Application number: 2024/93043	
What is the application for?:	Certificate of lawfulness for proposed erection of single storey side extensions
Address of the site or building:	85, Hartshead Lane, Hartshead, Liversedge, WF15 8AL
Postcode:	WF15 8AL

Type of comment: An objection	
Do you wish your comments to be published on the website anonymously?	No
Sharoz Ilyas Case Officer Kirklees Council Planning Department	
Subject: Objection to Planning Application for Certificate of Lawfulness (Ref: 2024-93043)	
Dear Sharoz Ilyas,	
<p>I am writing to formally object to the above planning application for a Certificate of Lawfulness pertaining to the proposed erection of single-storey side extensions, an outbuilding, and a front porch at 85 Hartshead Lane, Hartshead. Upon review of the submitted Design and Access Statement, I believe the proposals raise significant concerns regarding compliance with planning policies and the Kirklees Design Guide.</p>	
<p>1. Overdevelopment in a Green Belt Area The property is located within the Green Belt, where strict controls are in place to prevent urban sprawl and maintain openness. The cumulative footprint of the proposed and existing extensions, as stat

Drawing: **PROPOSED SITE PLAN.**

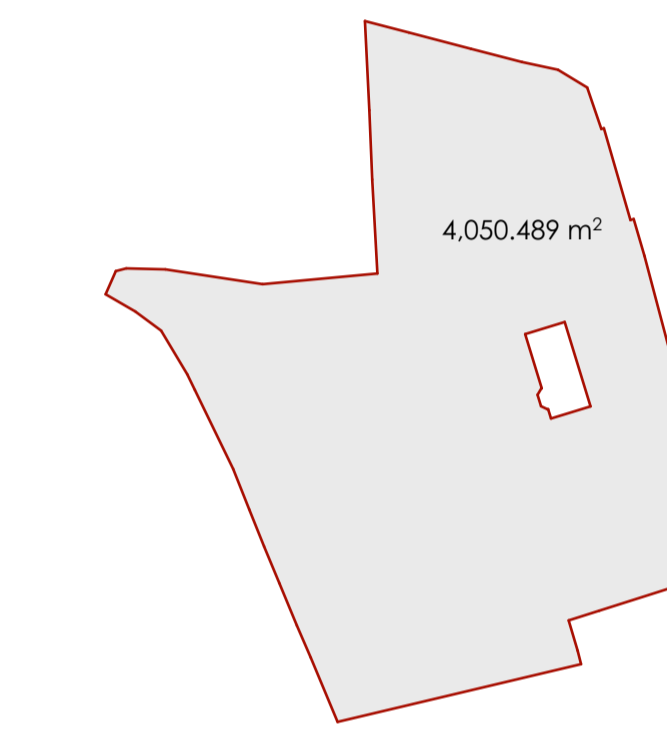
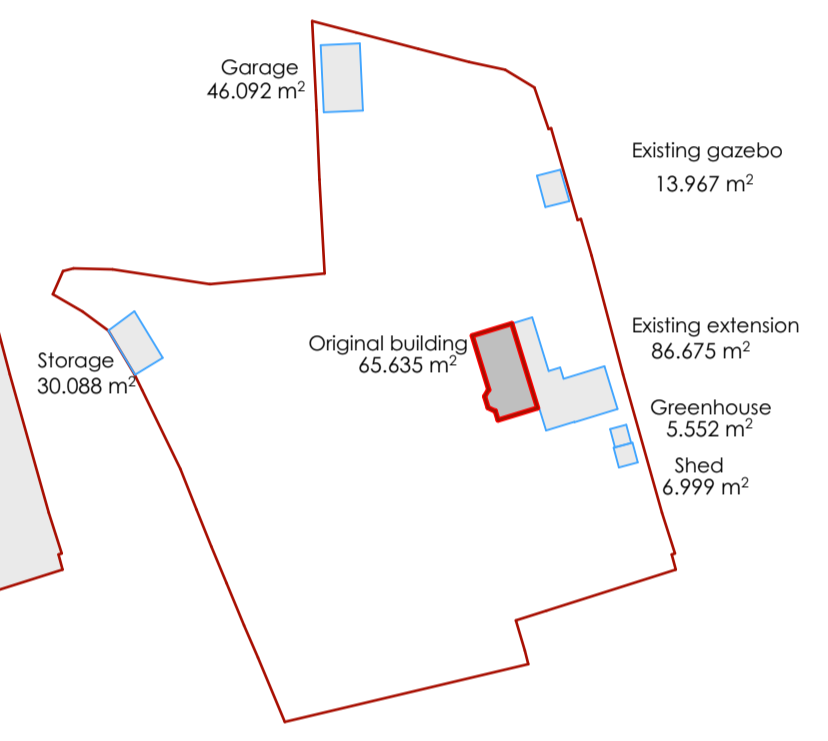
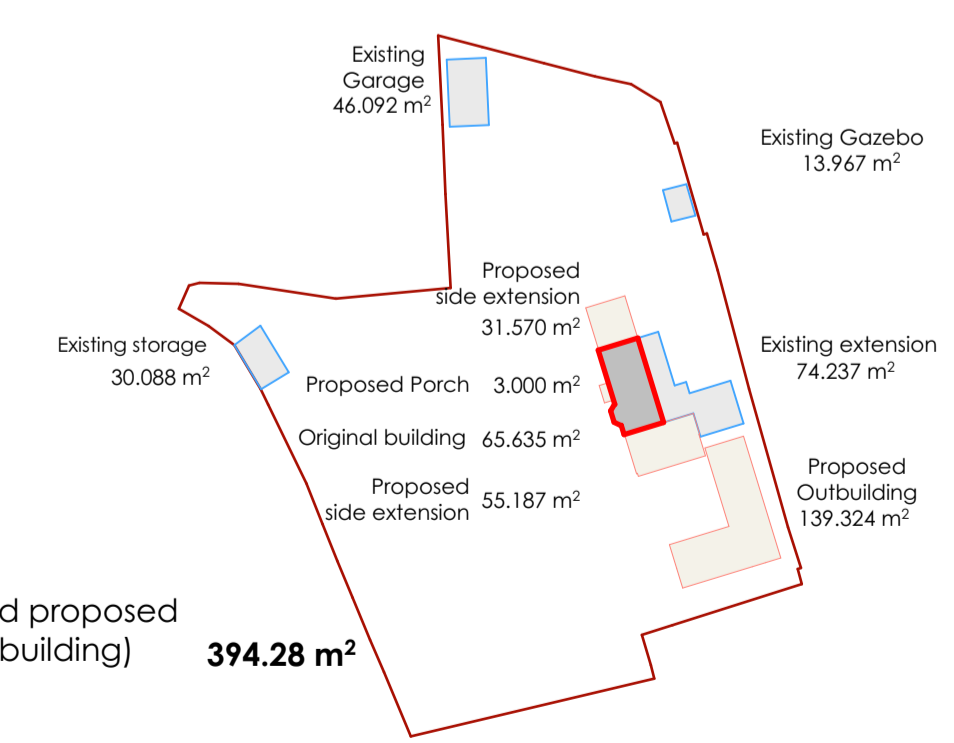
The combined footprint of the extensions and outbuilding, as a percentage of the curtilage, warrants closer scrutiny to ensure compliance with the maximum allowable coverage.

PROPOSED PLANS.

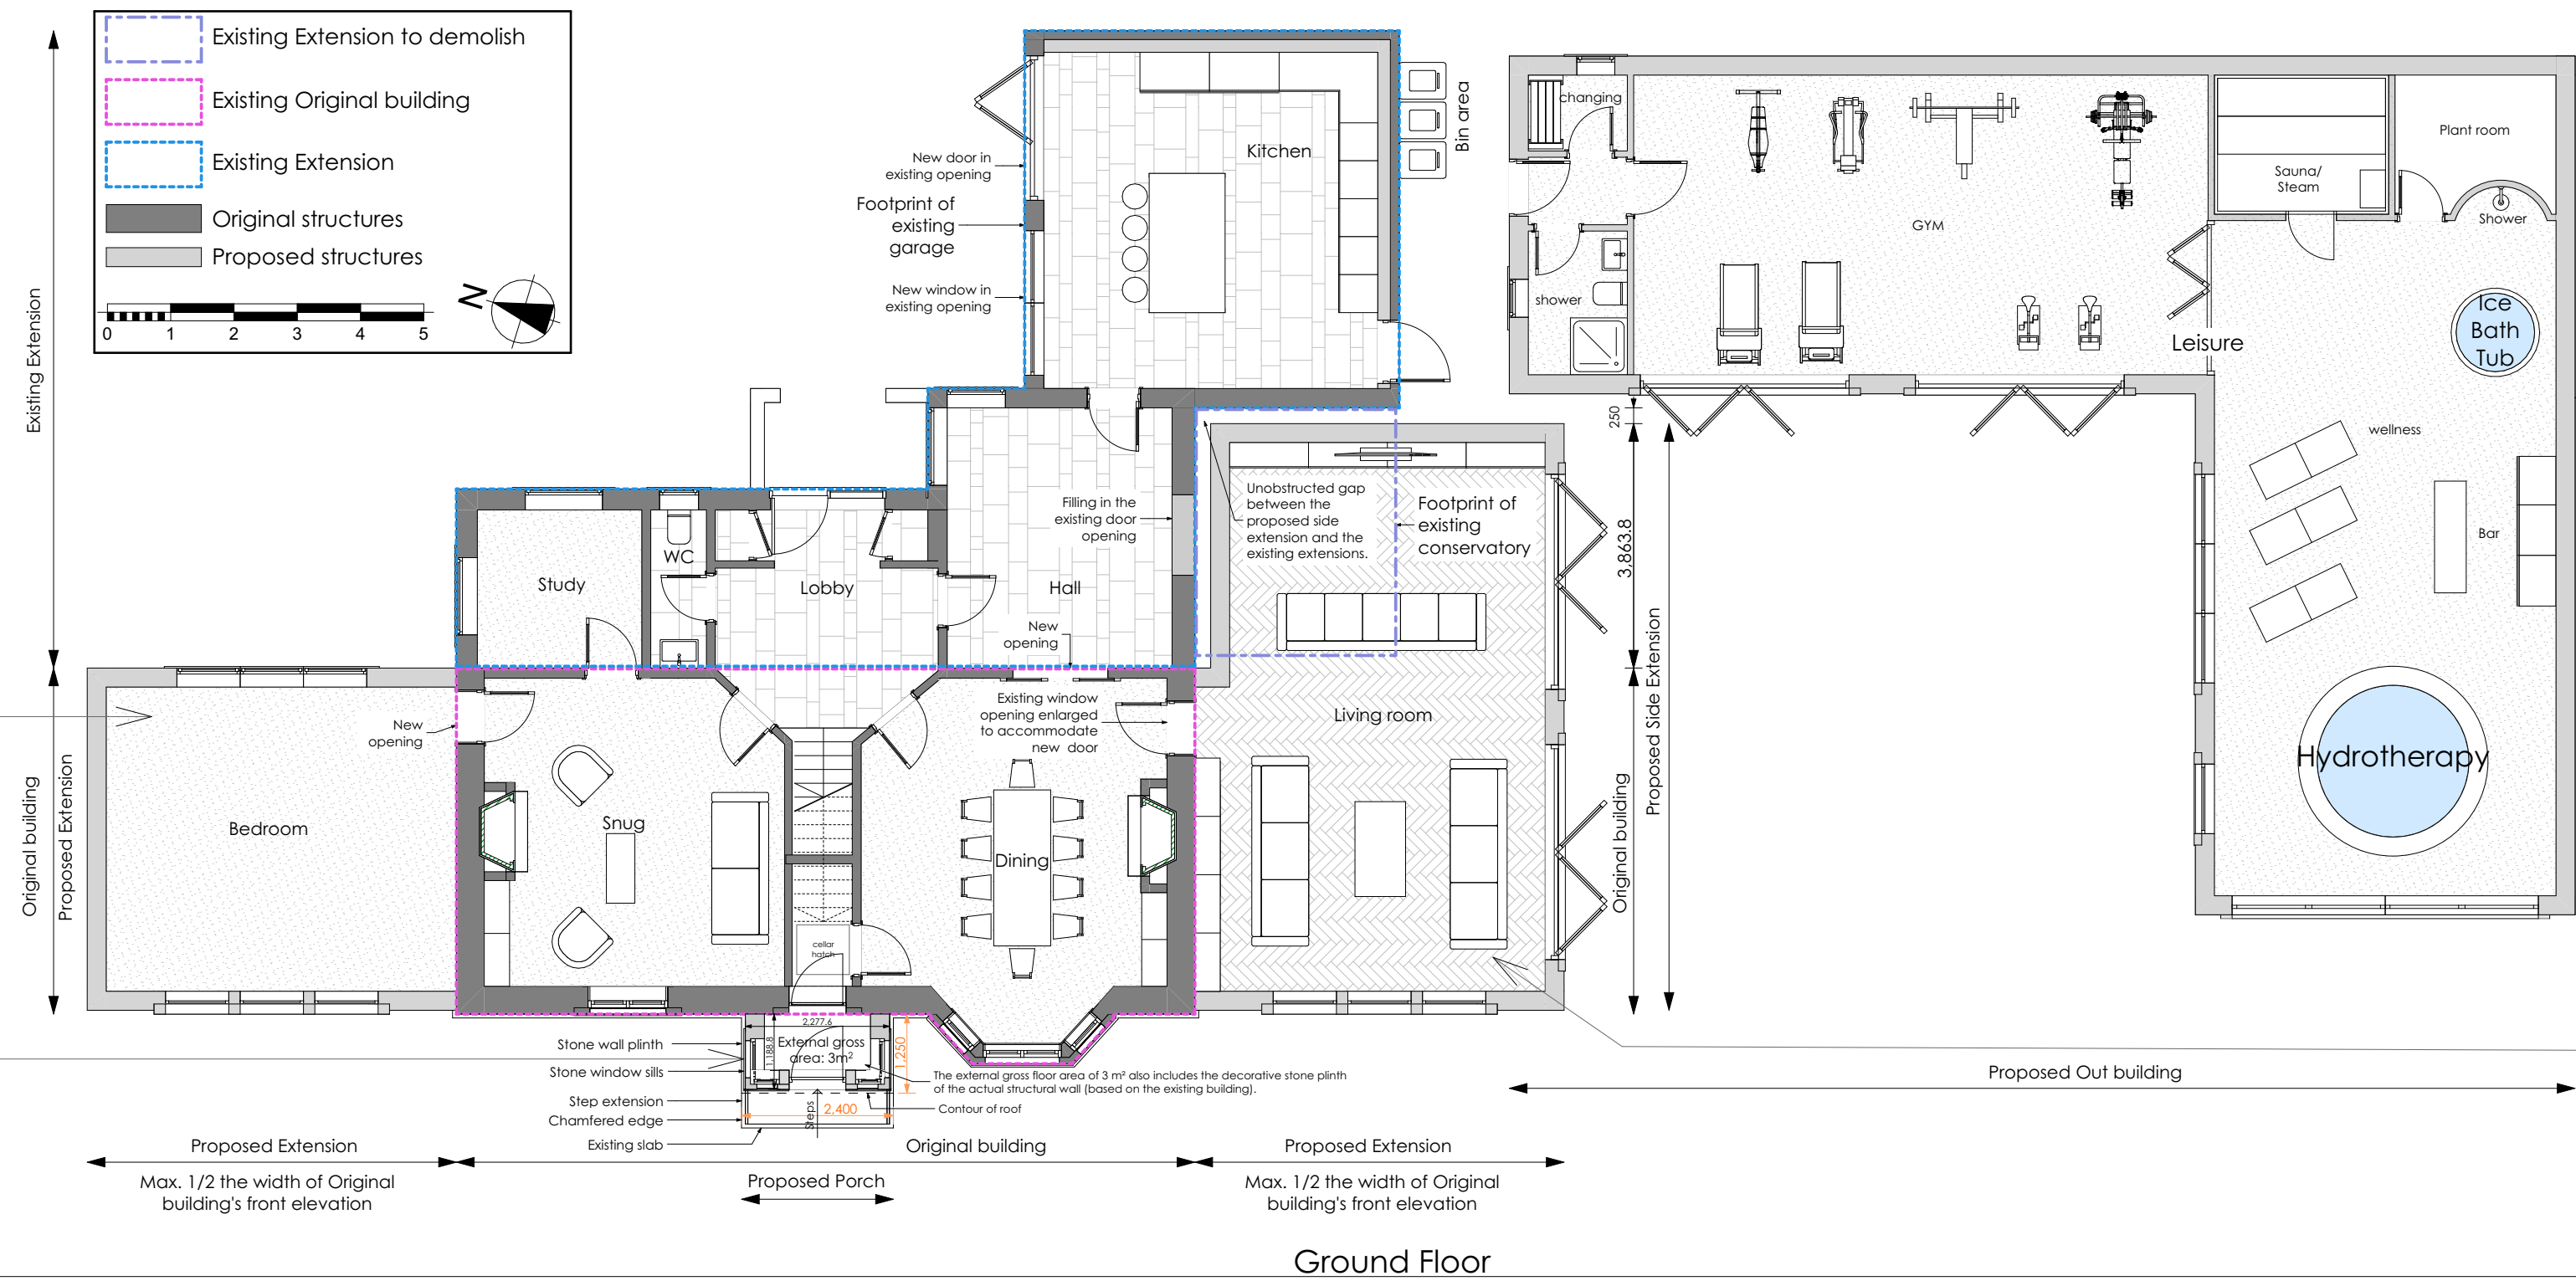
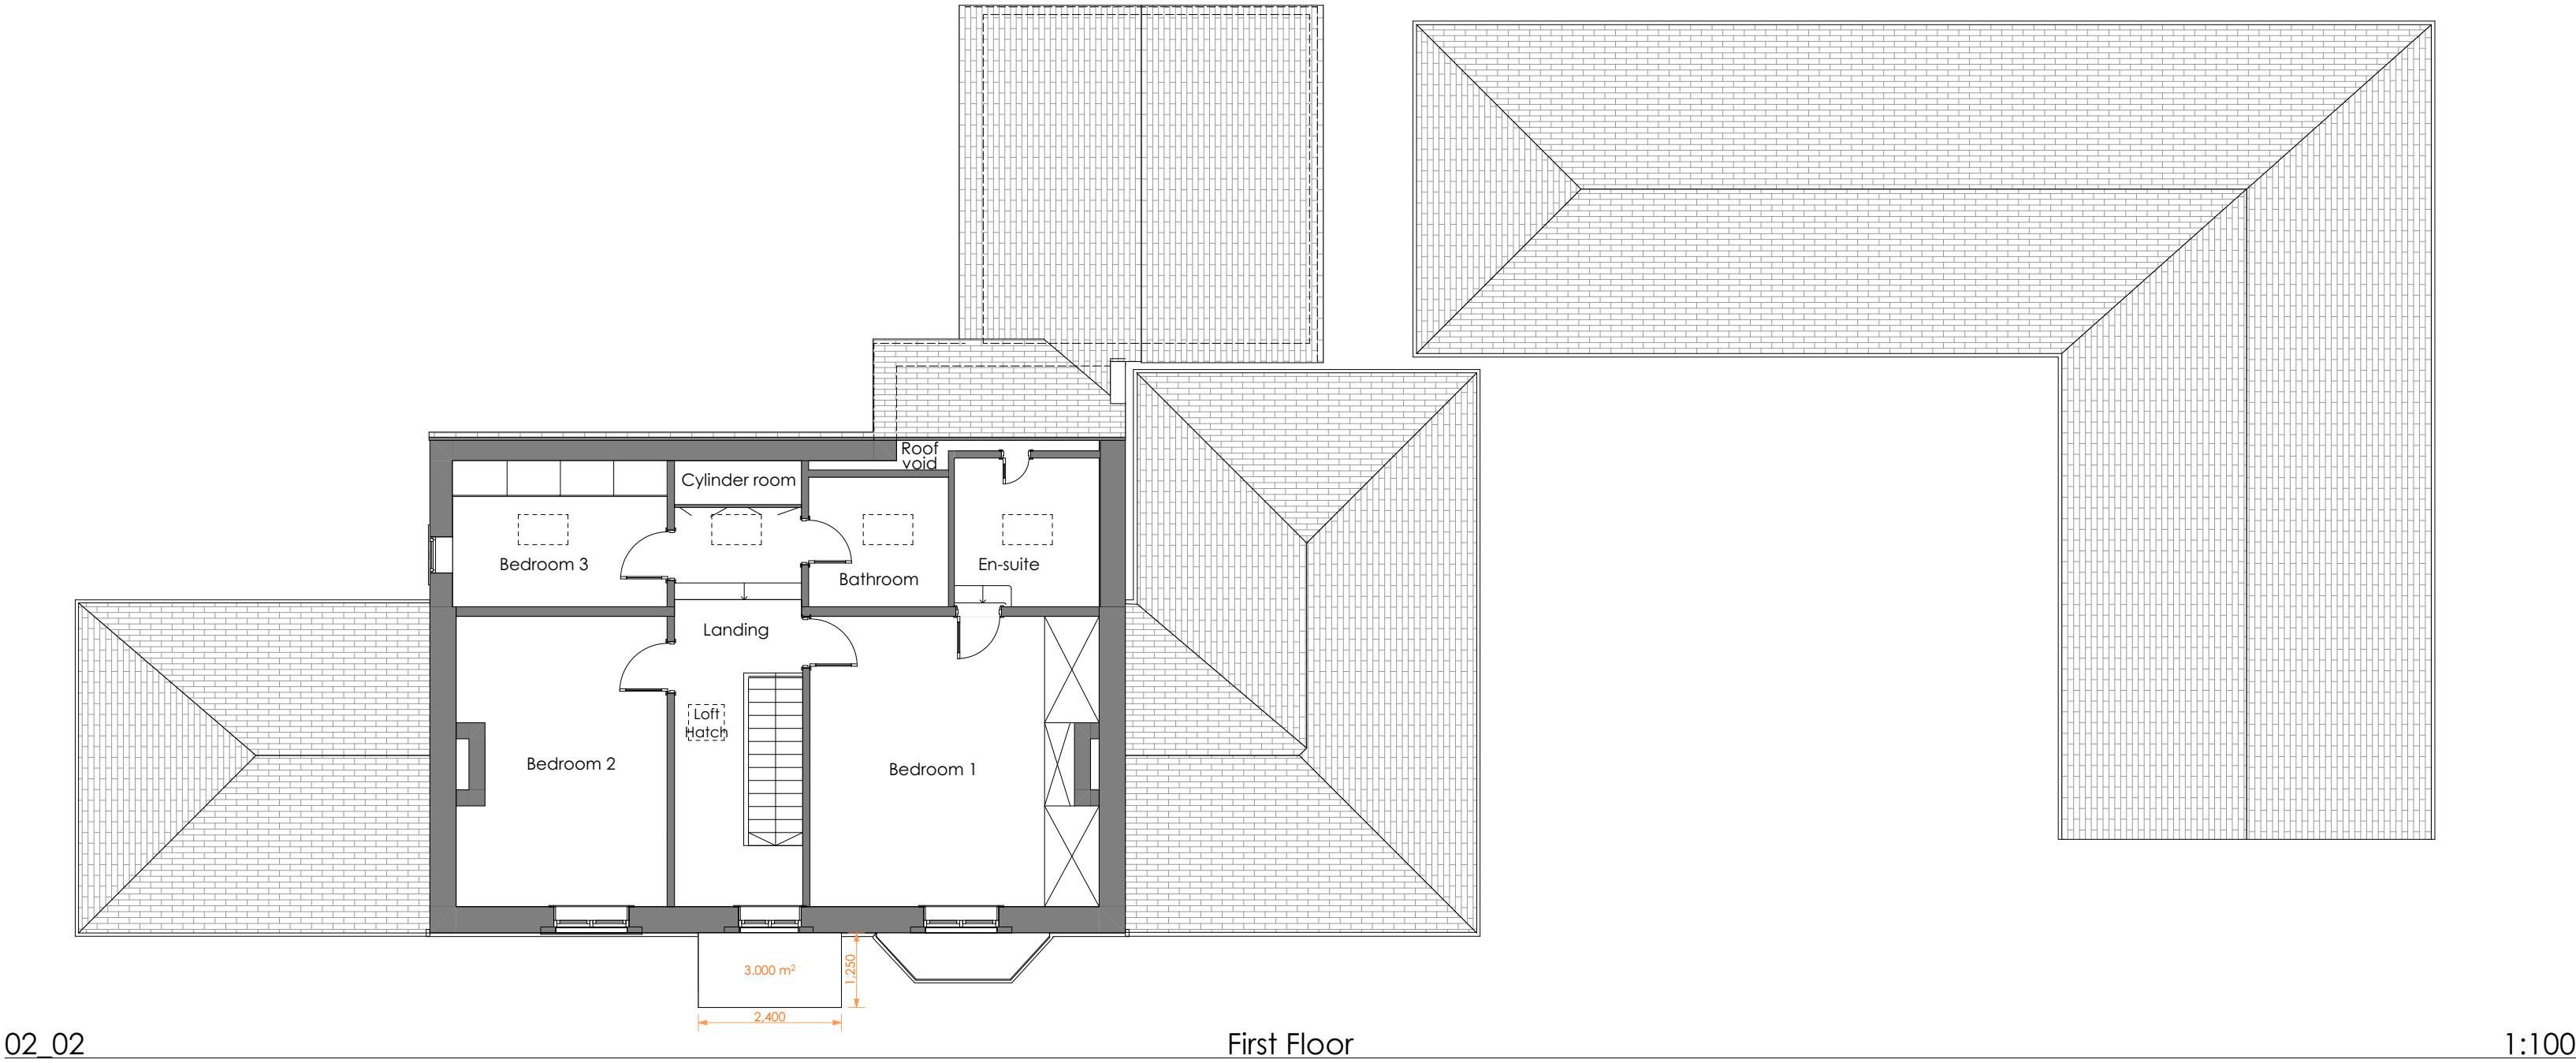
<p>2. Non-compliance with the Kirklees Design Guide The Kirklees Design Guide emphasizes the importance of extensions and alterations being subordinate to the original building and maintaining the character of the area. The proposed side extensions, combined with the substantial new outbuilding (154.37m<sup>2</sup> footprint), create an overbearing and incongruous development that undermines the rural character of the Green Belt setting. The guide also stresses the need for new developments to respect the scale, materials, and architectural style of the existing property and its surroundings. The extent of these proposed works risks dominating the site and detracting from its established character.</p>

3. Visual Impact and Harm to Openness The introduction of a large outbuilding and additional side extensions will significantly alter the visual appearance of the site, which is currently characterized by its open and well-spaced layout. This intensification of built form conflicts with the aim of preserving the openness and visual amenity of the Green Belt. The proposed porch and side extensions, though described as modest in height and size, contribute cumulatively to the visual clutter and massing on the plot.

The proposed outbuilding's height and proximity to boundaries could breach Class E criteria.
